January 24, 2018

RE: Comment Response for Front Range-Midway Solar Project, LLC Application for a Wind/Solar Energy Generation Overlay (WSEO), Submittal #1,

Drawing No: 7 of 16

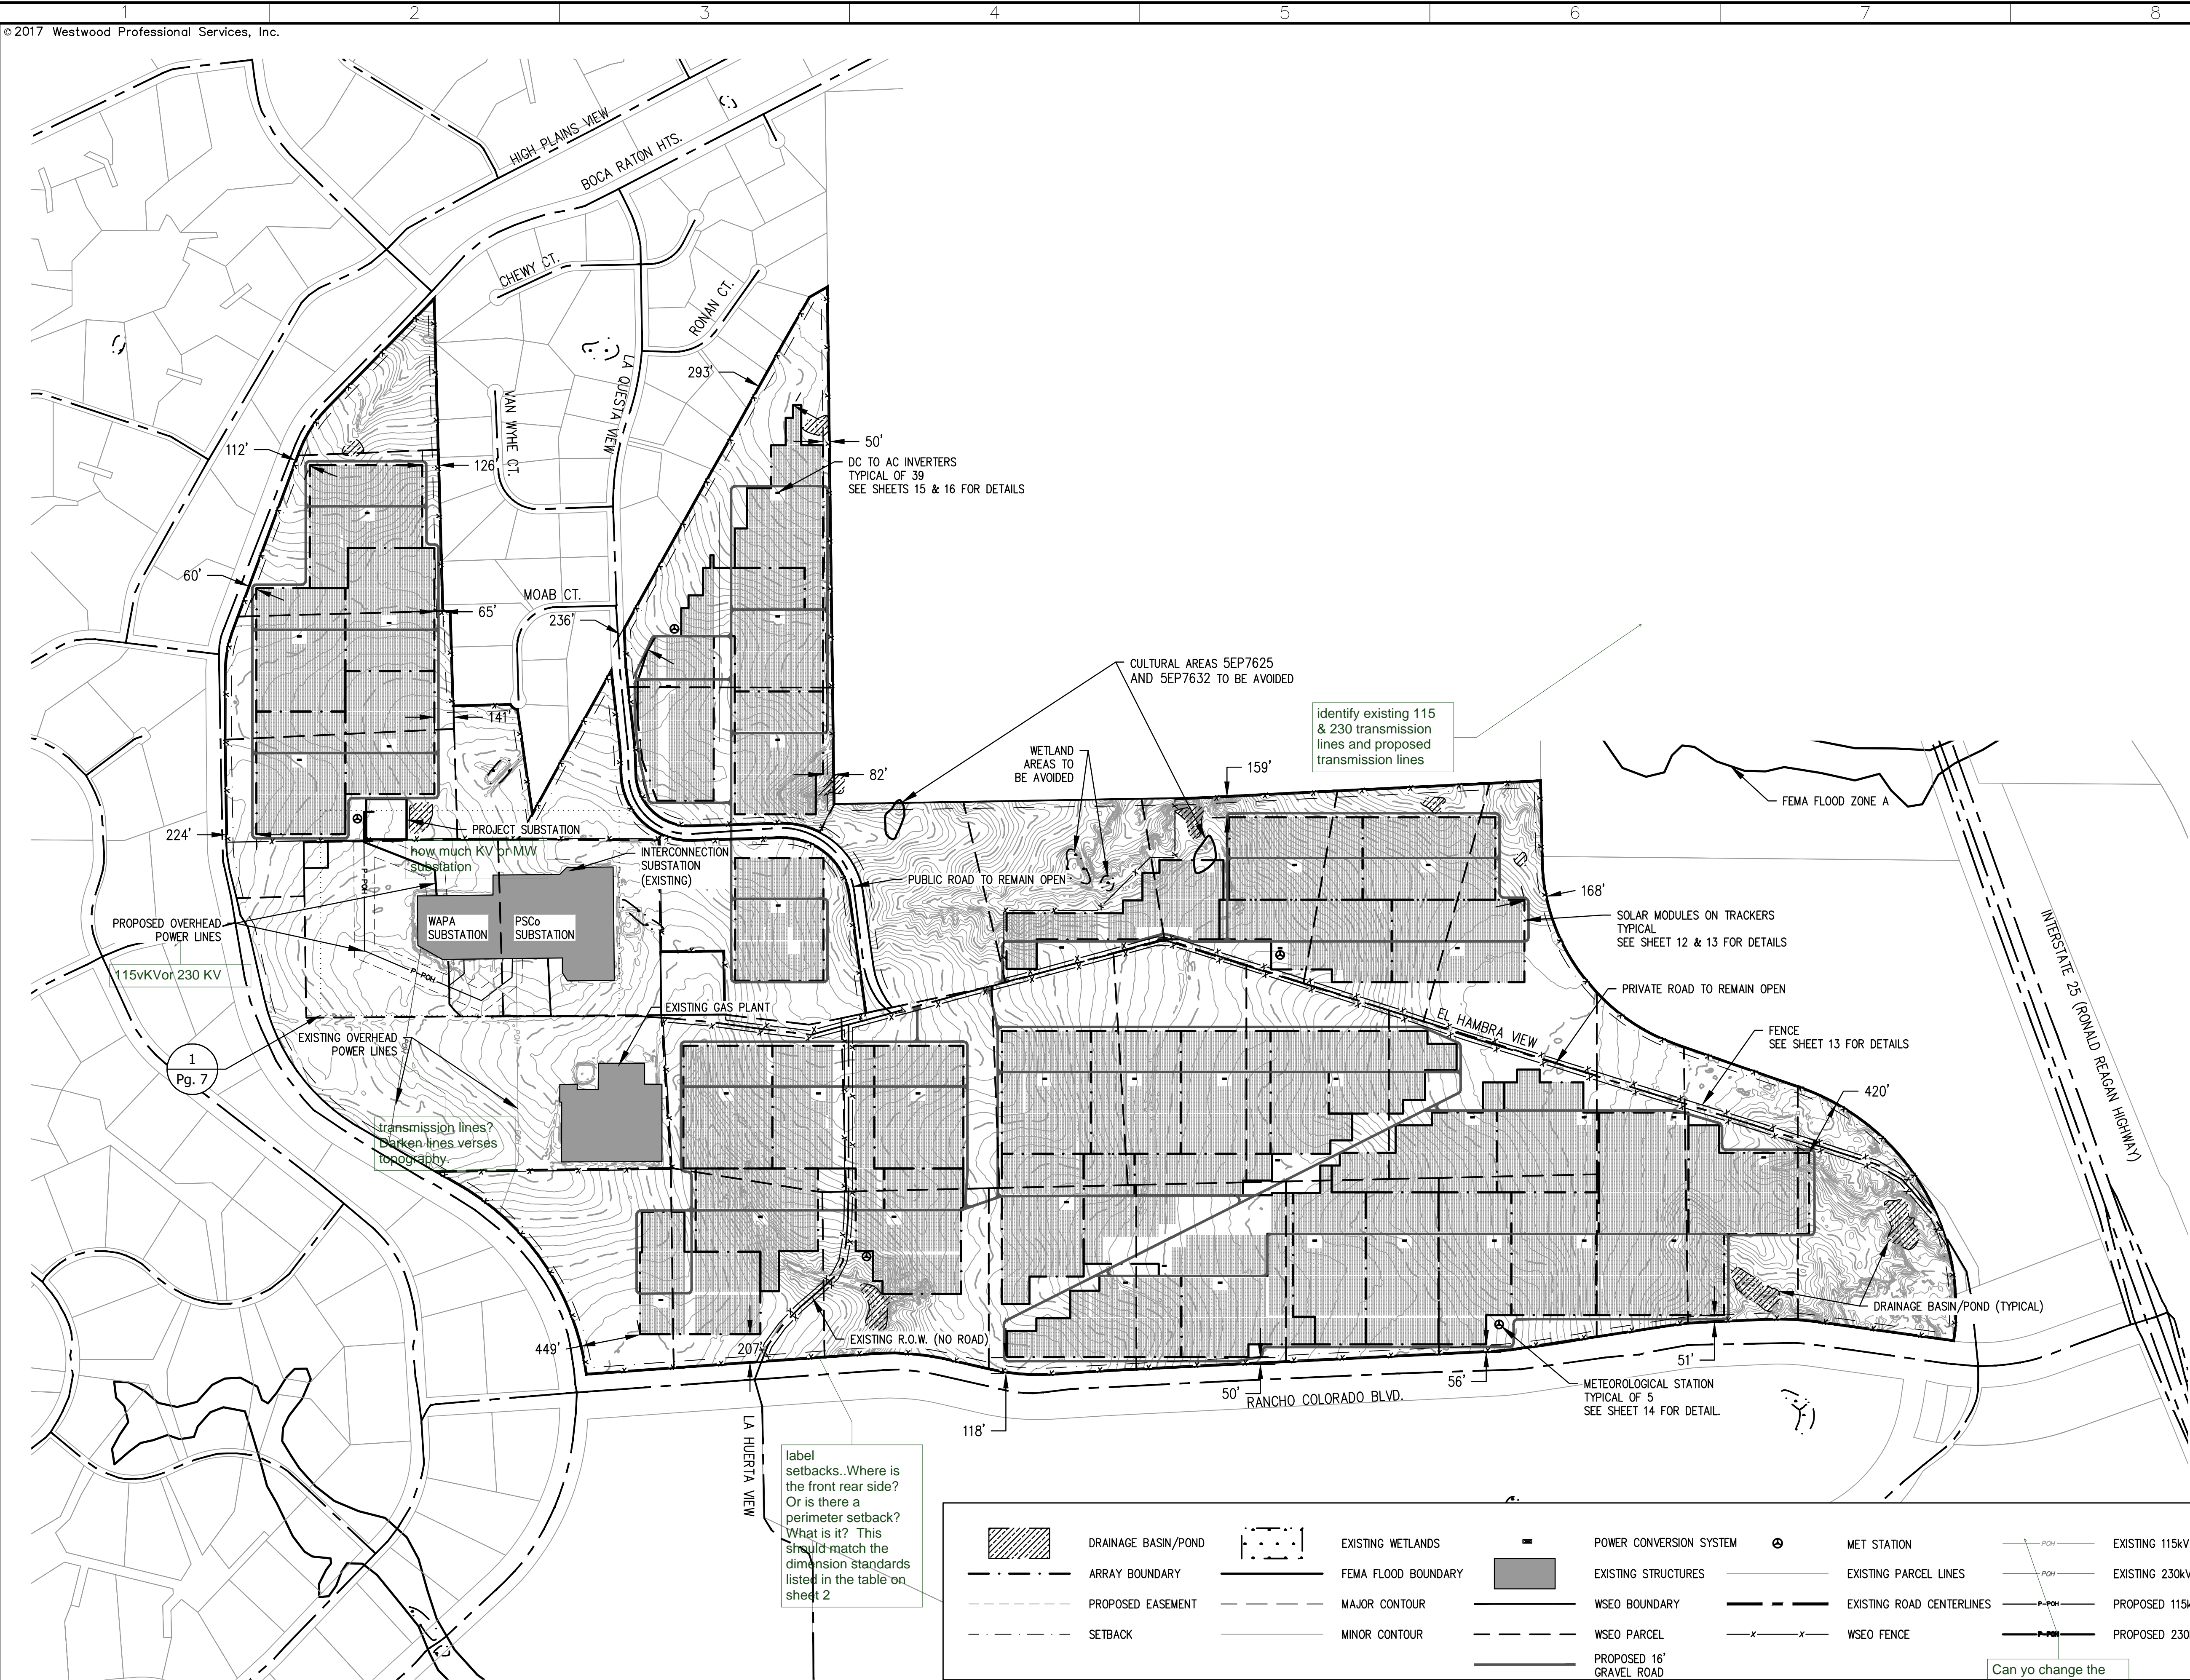
- I. Two class III cultural sites (prehistoric) were identified within the project boundary area. [lithic reduction locale, surface assemblage is fragmented- moderate potential for buried cultural materials] The State Historic Preservation Officer (SHPO) and [Front Range-]Midway Solar have agreed to preserve the sites by avoidance; however the area is shown to have solar arrays.

Identified sites to be avoided

Applicant is showing solar arrays on site

2. The sites (5EP7625 and 5EP7632) identified in the September 2016 final environmental assessment are located at the northern portion of the property east of La Questa as depicted above. A letter from the SHPO has been provided. If avoidance cannot be adhered to further excavation would be necessary, please provide further documentation.

Response: Preliminary design has been updated to avoid the potential archeological sites identified in the Class III Cultural Resources Inventory and recommended for avoidance. Please see updated Site Plan (Attachment M), which depicts avoidance of archeological sites. All other Attachments show avoidance of these sites, including the WSEO Plan.

WSEO Details - Fence  
Details and Solar Panel  
Profiles

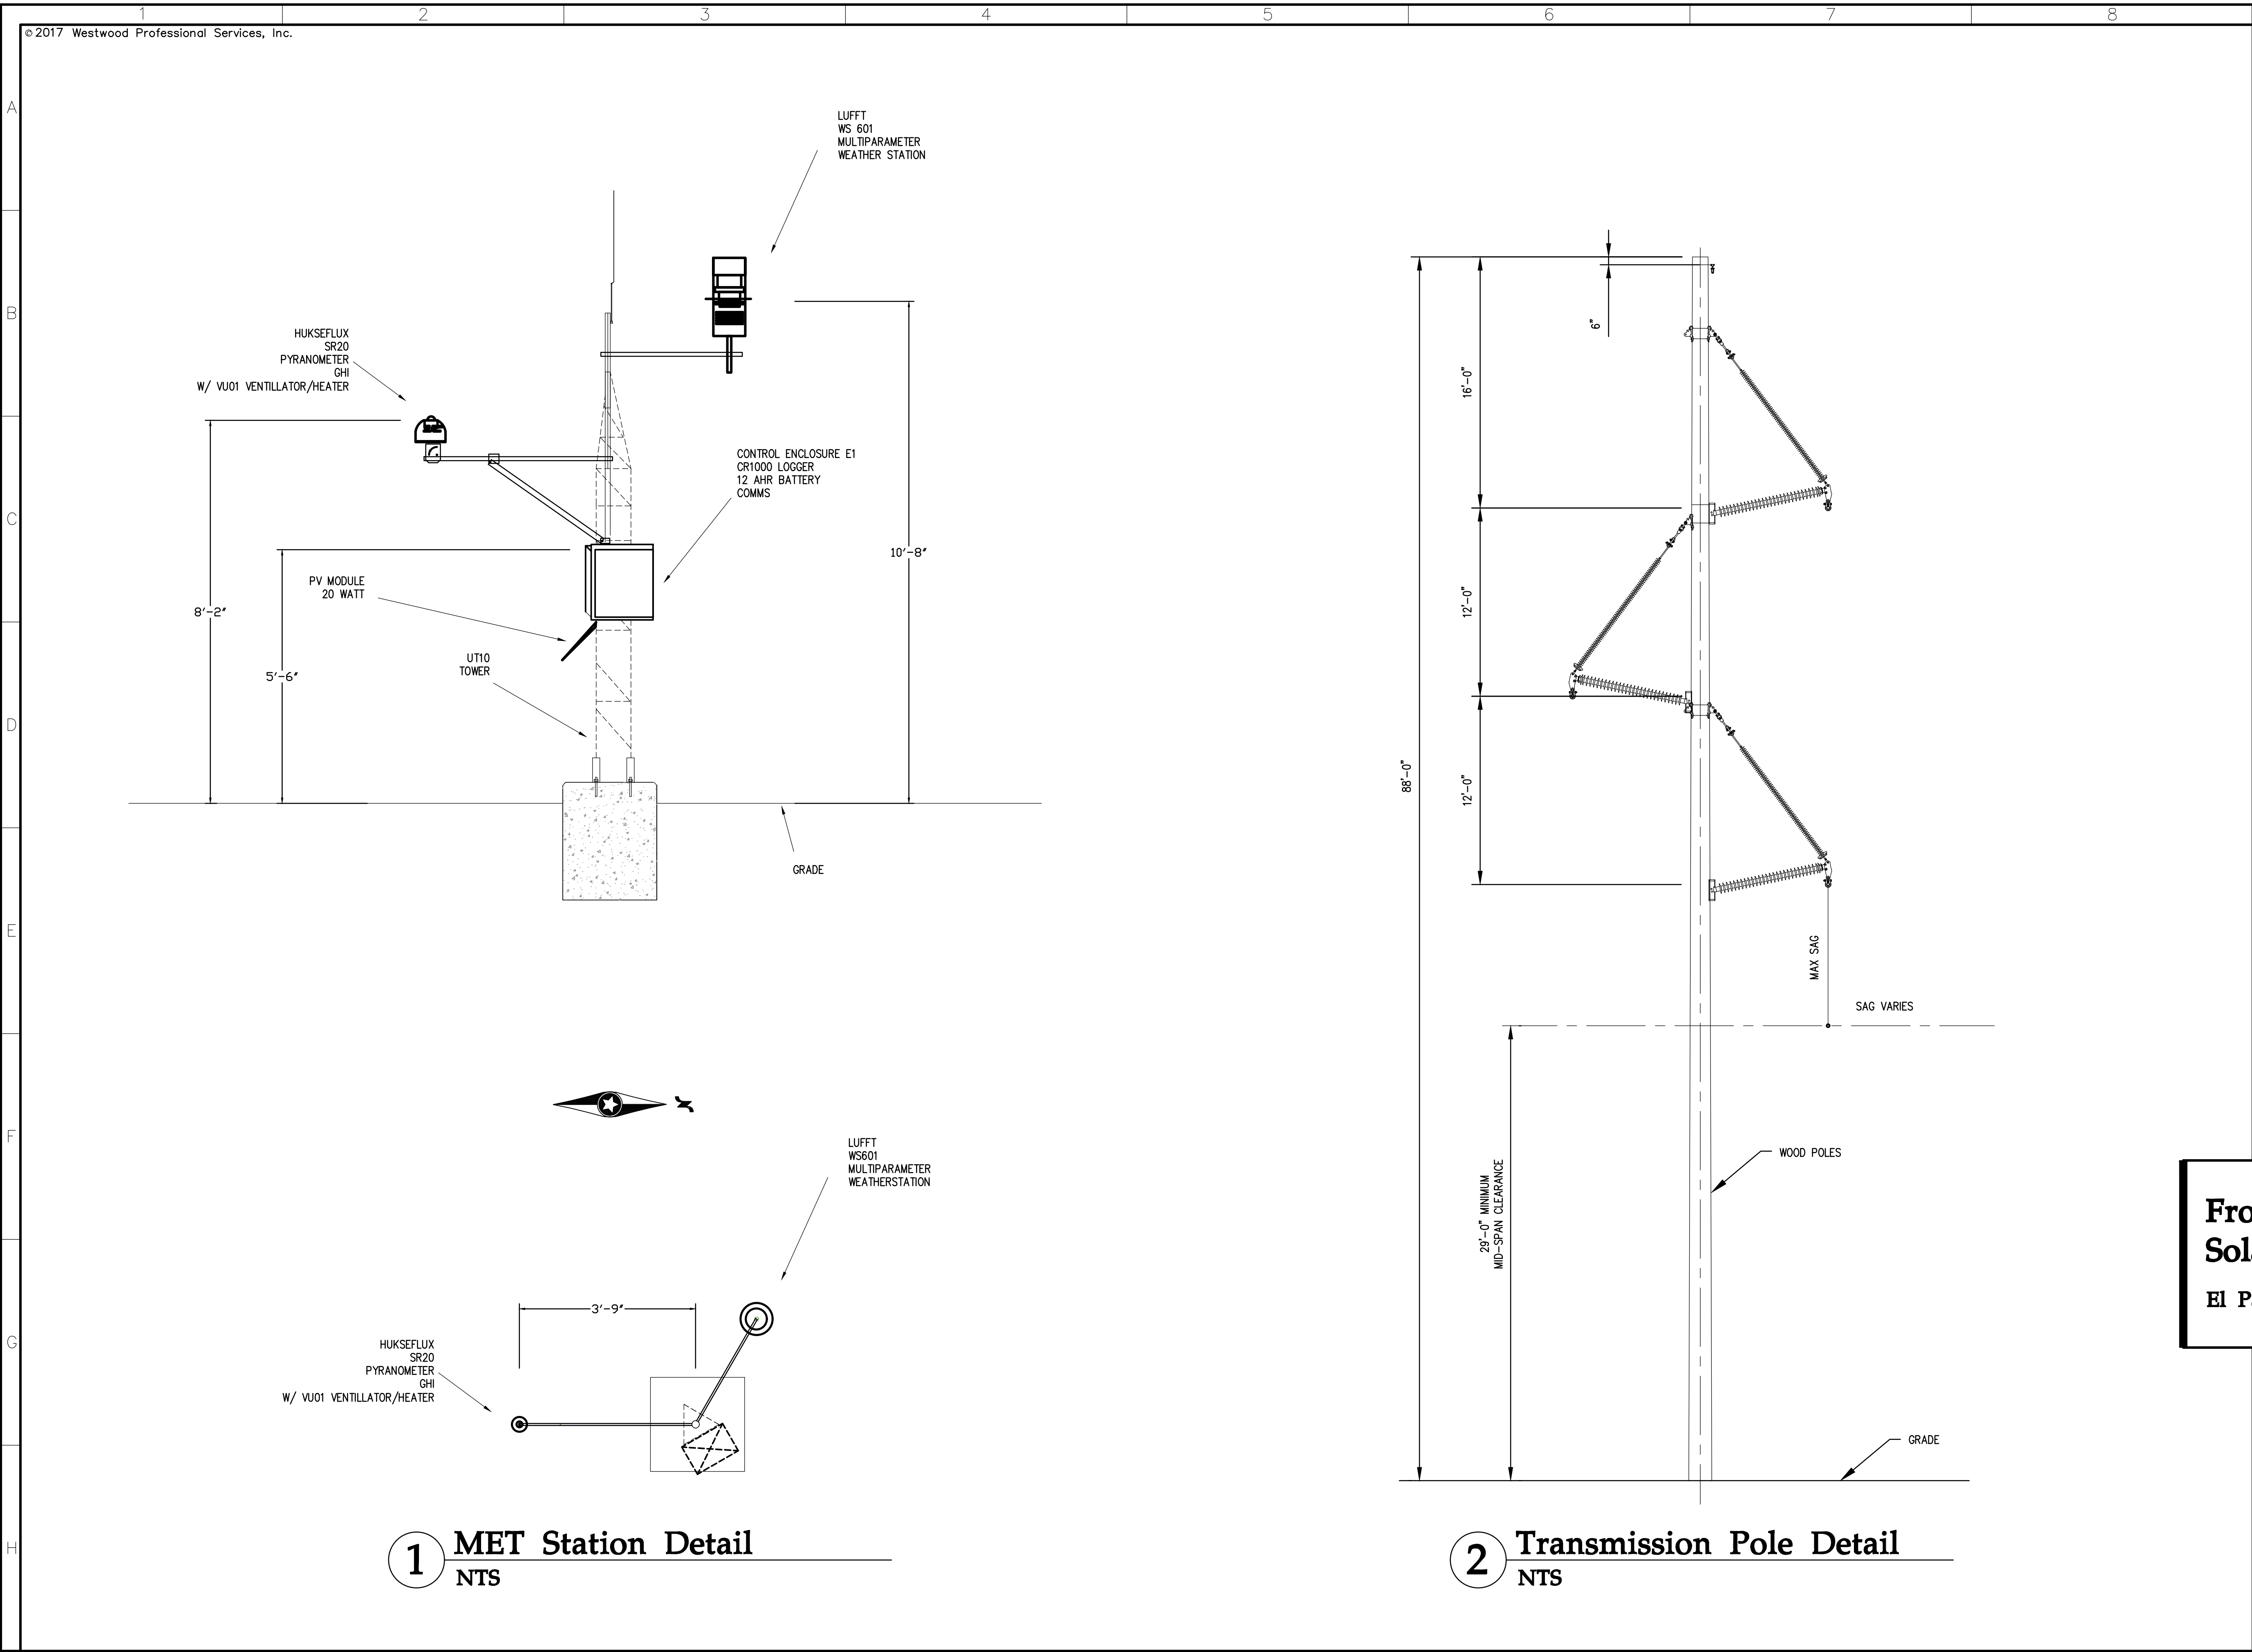
6. Visual Quality and land use Compatibility do not identify buffers, setbacks, fencing adjacent to residential homes or lots. This should be discussed.

Response: The discussion in WSEO LOI Sections CPP 6.0 Land Use, Policy 6.1.8, and CPP 9.0 was updated to address this comment.
